From: Kate B [REDACTED]
Sent: 13 May 2022 13:32
To: Planning <Planning@arun.gov.uk>
Subject: Bedford St Toilets

I write to you concerning the design for the new toilets at Bedford St in Bognor, near Morrisons, a much needed overhaul.

PROPOSED FLOOR PLAN

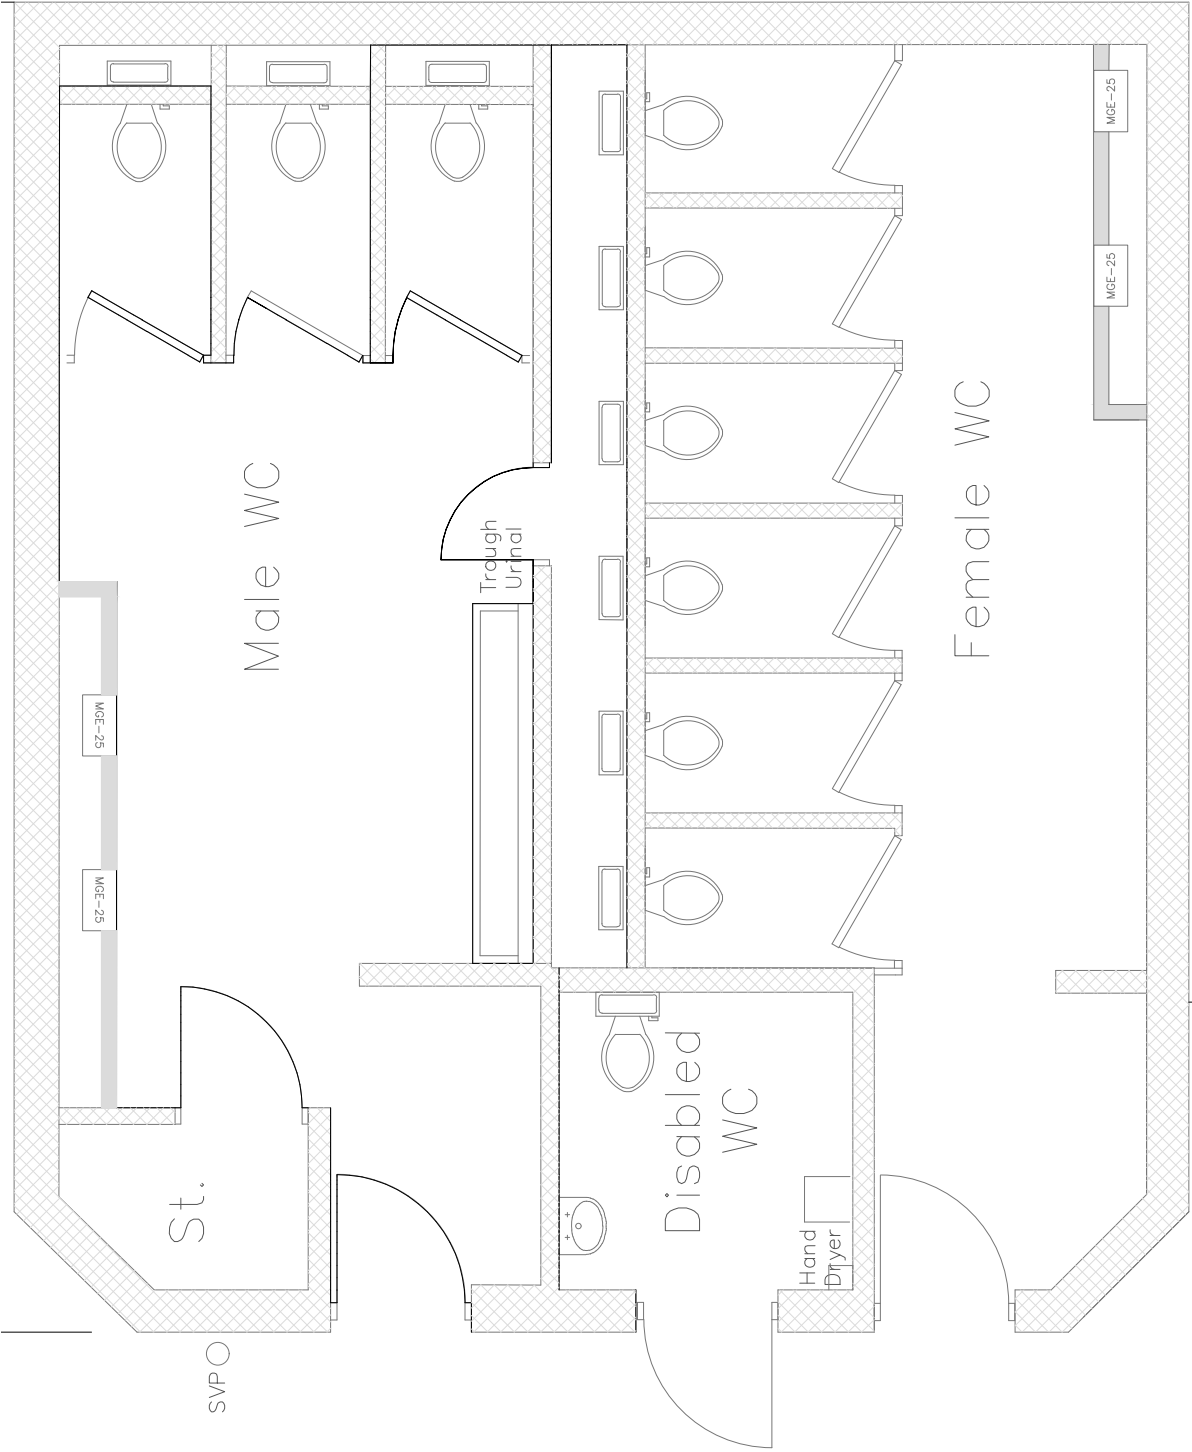
I personally feel it would be much better to have fewer toilets that opened up onto the street and were larger to accommodate buggies, children, wheelchairs etc. There may be some already like this in the district but I am thinking of the CDC ones at M&S carpark and Florence park in Chichester.

Thesw do unisex with more inclusivity and dignity. Men and women will be opening up to each other in the shared central space in Bedford St, plus the stalls are as small as the regular ones, not much privacy between men and women or space for having your kids in with you. I'd be concerned with separating from my children in a mixed space and a lack of safe buggy space outside the stall. I'd also feel awkward opening up to a man using the opposite toilets and a lack of dignity.

Please give Bognor good quality unisex toilets, I understand Bognor town councillors have raised similar issues with the design.
